28 January 2016
Job No: A15008

NEUROSCIENCE RESEARCH AUSTRALIA
ADDITIONAL FITOUT STAGE 2A – LEVEL 3
Review of access for people with a disability

Drawing reviewed as received from Cox Richardson 21/01/16:

Drawing Title	
LEVEL 3 FLOOR PLAN	
Drawing Number	Rev.
PA-203-2D	09
Date	
DECEMBER 2015

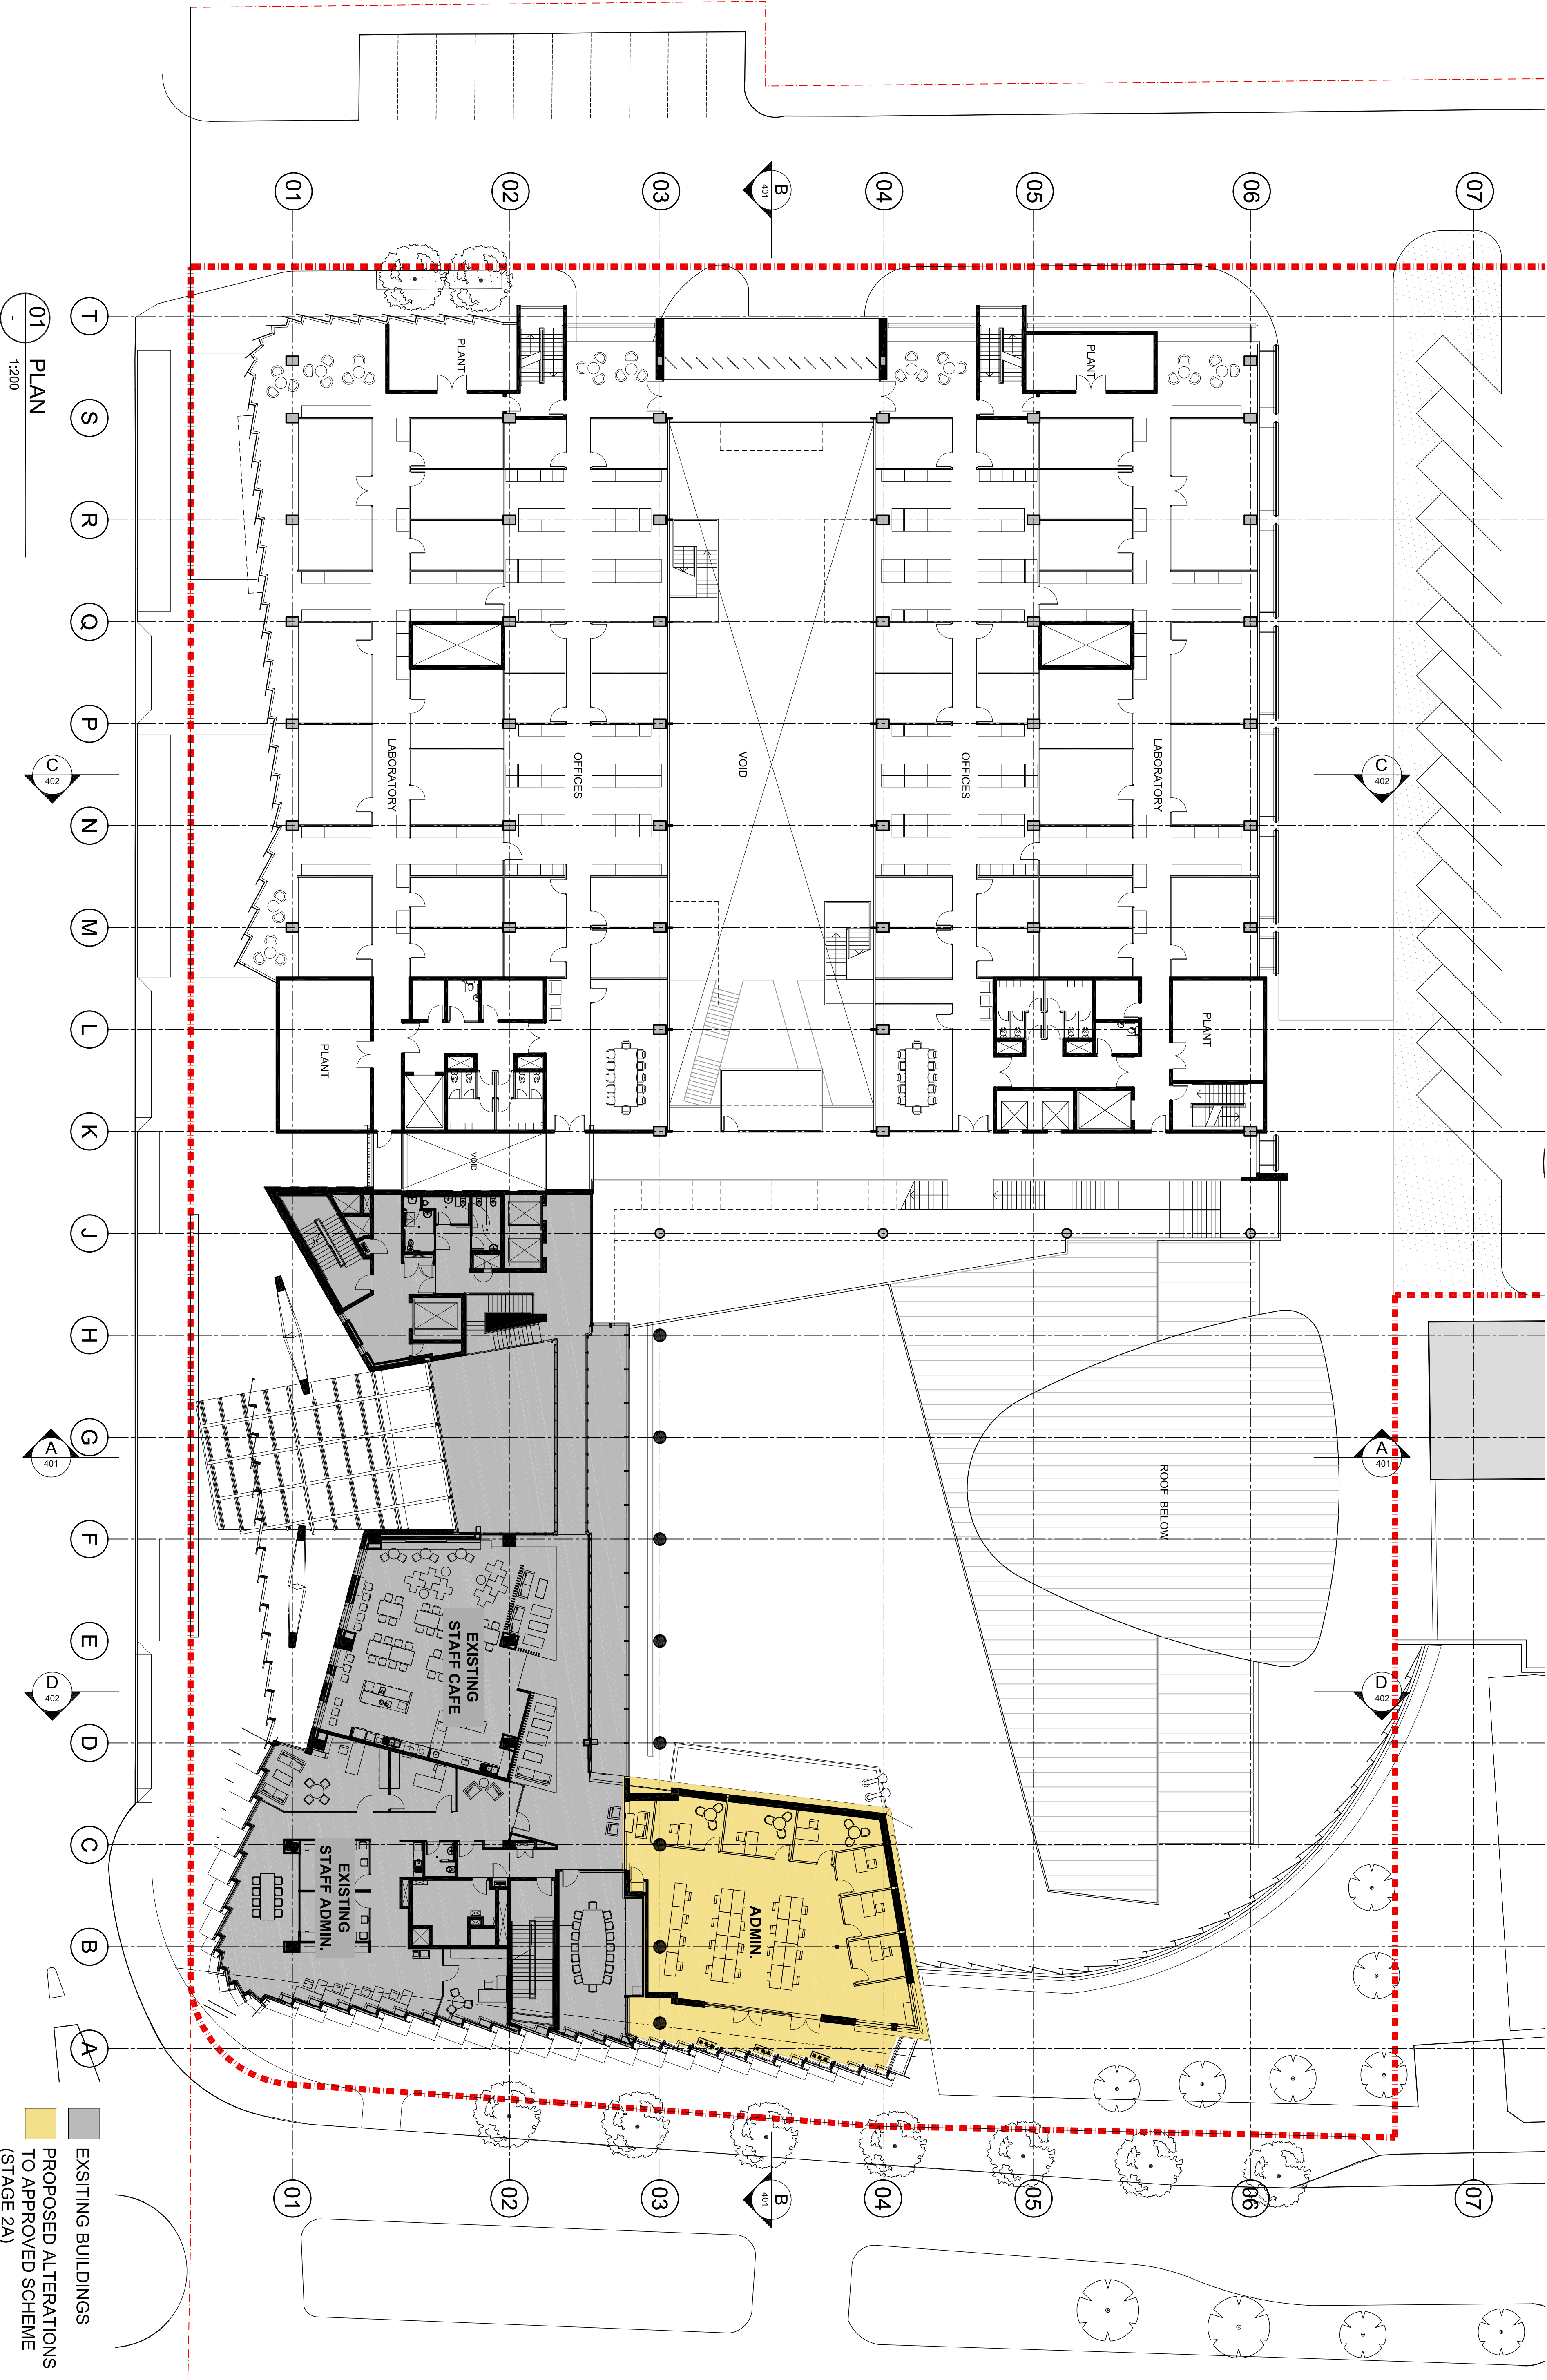
- a level threshold (maximum lip 5mm) be provided at at least one set of double doors on the path of travel to the eastern verandah. Installation of a threshold ramp compliant with AS1428.1 would provide an acceptable alternative link.

- Ensure a minimum 850mm clear door opening is provided at the active leaf of the accessible doorway.
- To meet the BCA part D3.12 (2015), ensure unframed glazed doors and walls are provided with visual indicators to fully comply with AS1428.1 clause 6.6 (2009) and that doorways are provided with luminance contrast to meet the requirements of AS1428.1 (2009) clause 13.1.
